Ashley King (Developments) Ltd
T/A Ashwood Homes
1 Goodison Road,
Lincs Gateway Business Park
Spalding
PE12 6FY

Monday, 27 March 2023

Re: H09-0288- 15 Land Off Balmoral Way, Holbeach, Spalding - Discharge of Planning Condition 4

Please find the information below and enclosed for you to consider the discharge of condition 4 following the response dated 20-03-2023

Typical Strip Section A-A
scale 1:20

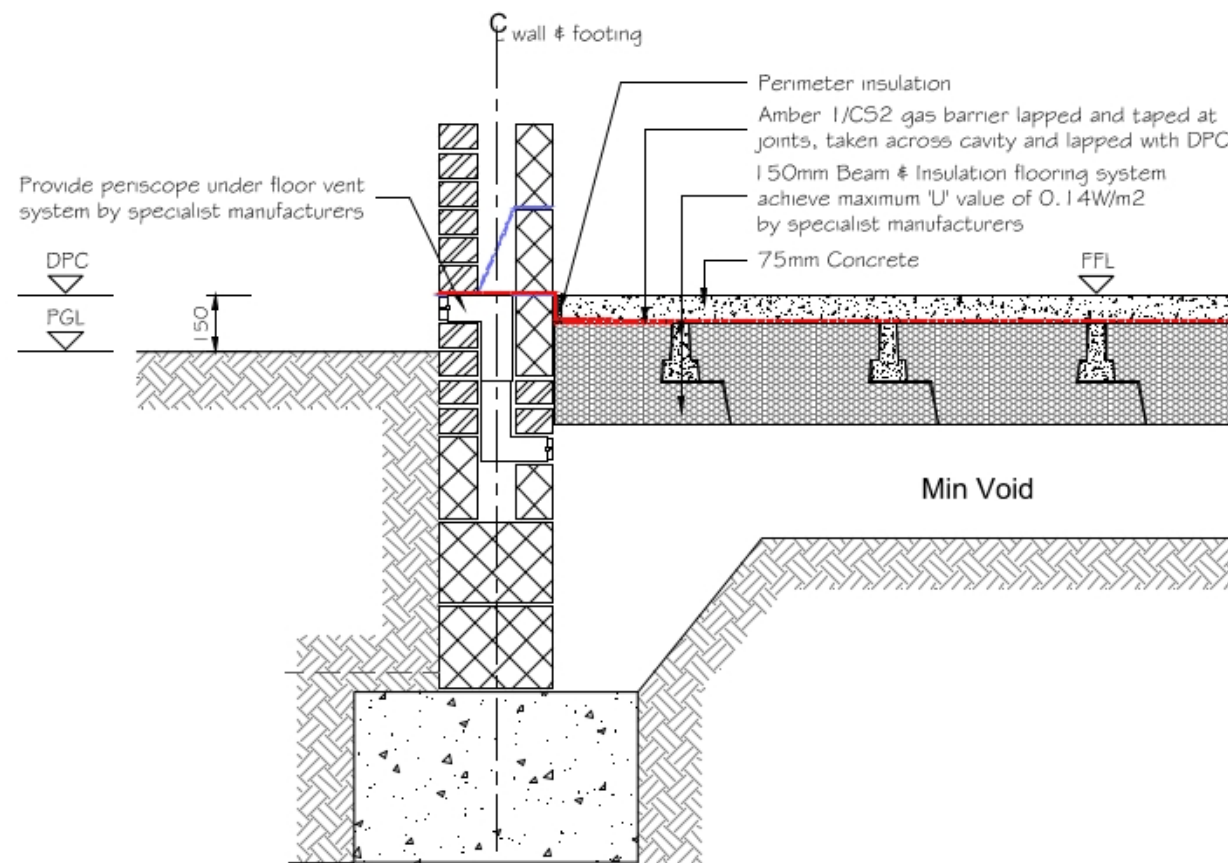
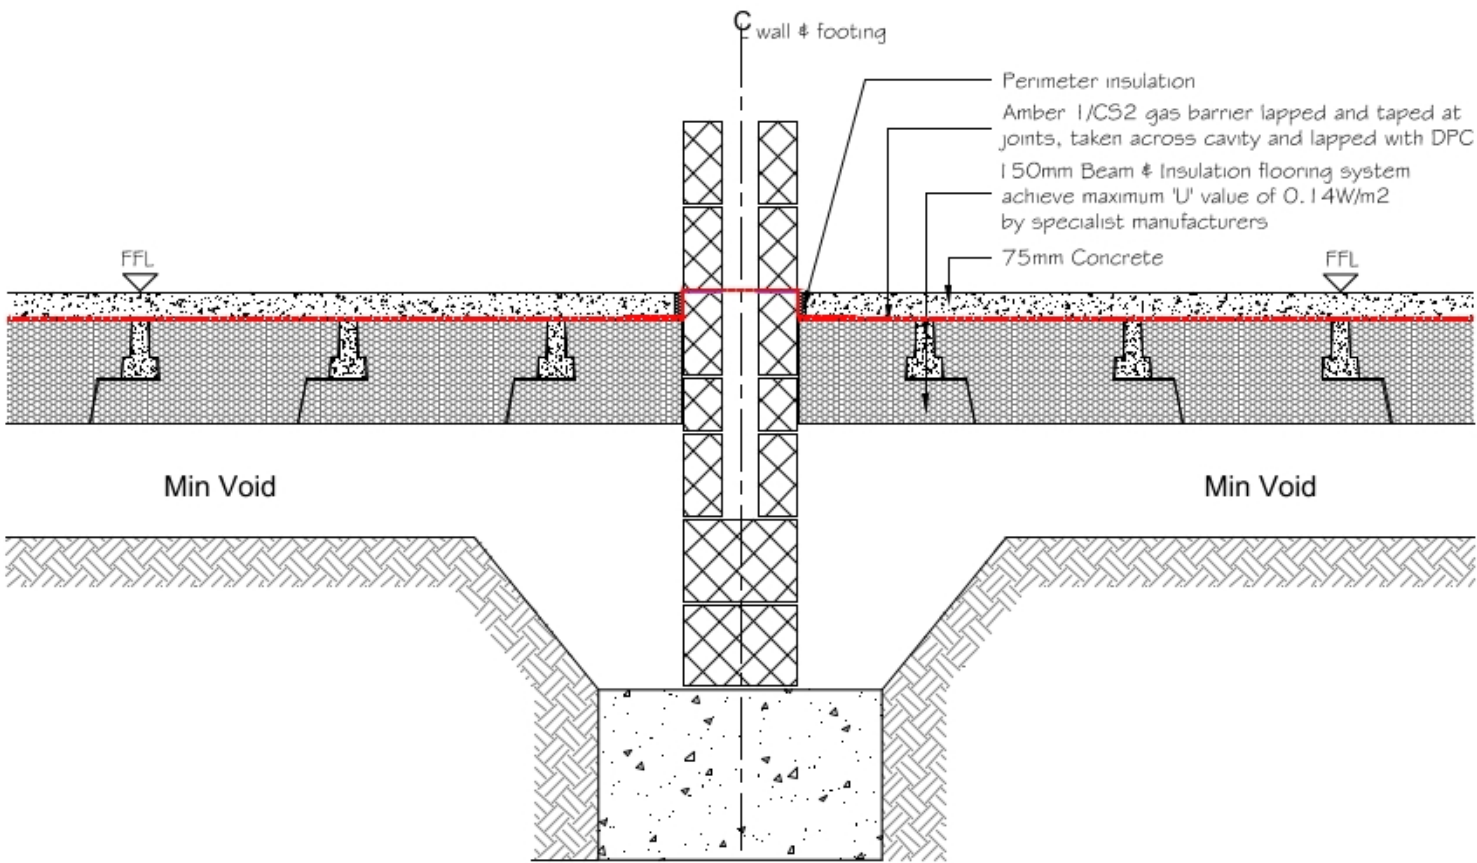
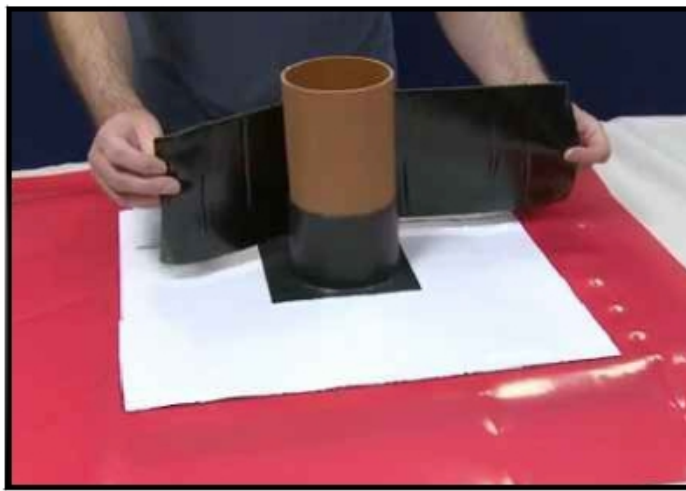
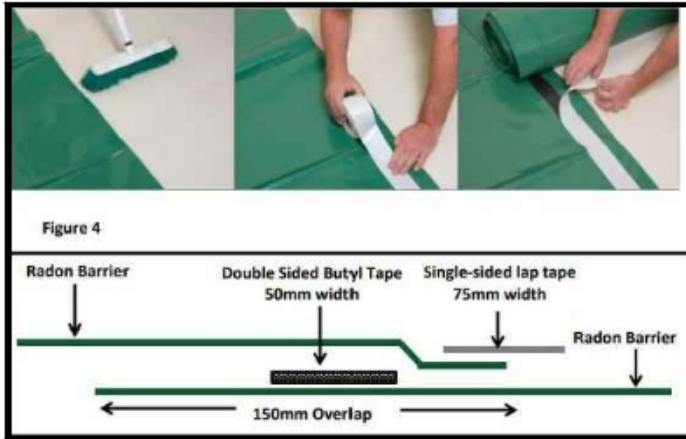
This supplementary report does not meet the verification requirements for gas protection measures as outlined in the technical guidance produced by YALPAG in 2016. For example, there are no plans or photographs, we do not know the competency of the installers or of the Harlor employee who carried out the visual inspection of the membranes. I appreciate that in retrospect it is not easy to evidence the installation process and that Geodyne have stated that 'no further works or mitigation are necessary', however there are limitations to accepting information obtained from third parties

All gas membrane works were undertaken in accordance with drawing 72-GMD-01 - Gas Membrane Detail, copy of which is attached.

This drawing was submitted to SHDC Building Control and we refer to the response dated 04-08-2020, copy attached, which confirms that works on site were being undertaken in accordance with this drawing.
